Department of Primary Industries

OUT15/34860

CBD-South East Light Rail project (SSI 6042 Mod 4) Proposed Modification

DPI Water has reviewed the Modification 4 application and provides comments below. Other divisions of DPI do not have any comment.

Figure 5: Approved (left) and Revised High Cross Park compound and substation location (right)
(Source: TfNSW, 2016)

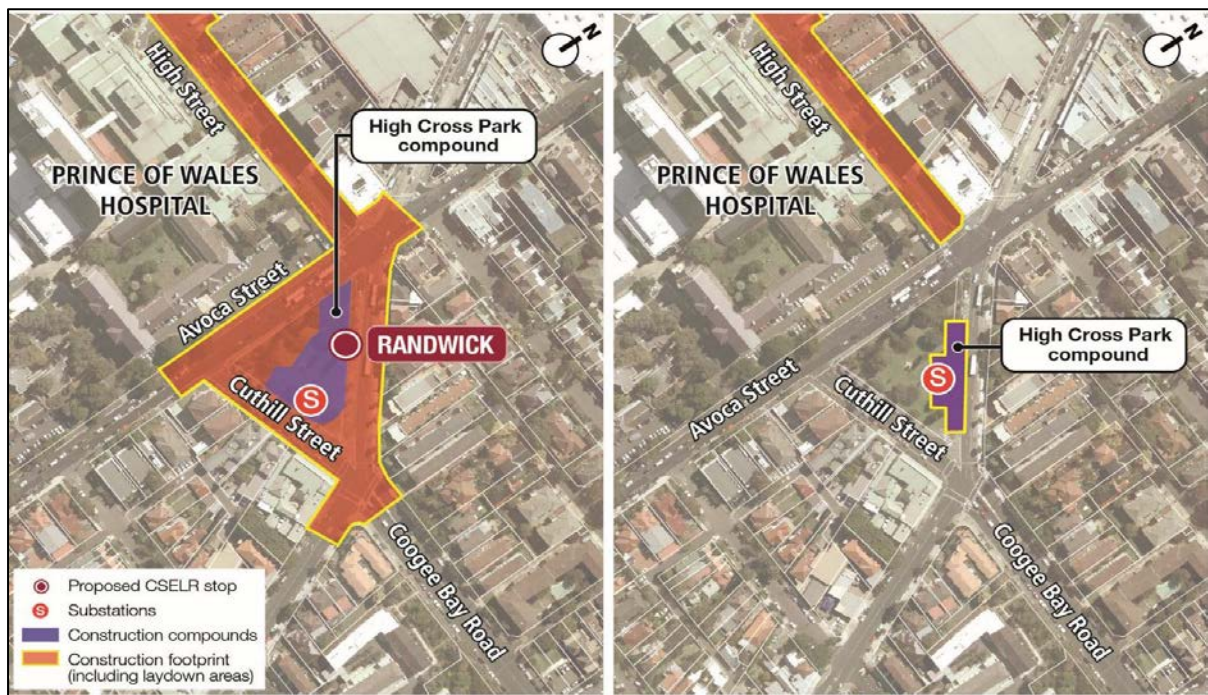
Section 3.2.6 of the Modification Report notes the location of the substation within High Cross Park has been refined and it is proposed to be placed underground within the Park and the depth of the substation would be approximately 8 to 9 metres below ground (page 21). It also indicates an underground connection would be required along Belmore Road and across the Avoca Street and Belmore Road intersection to provide a connection between the substation and the Randwick terminus.

Details are not provided on the depth of the proposed underground connection, nor does the Modification report indicate if groundwater is likely to be intercepted, or if dewatering is likely to be required.

There is likely to be some dewatering associated with the underground substation and the underground connection. It is recommended monitoring piezometers are established in advance. Dewatering will require management, and relevant management plans for the project should be revised to accommodate this modification.
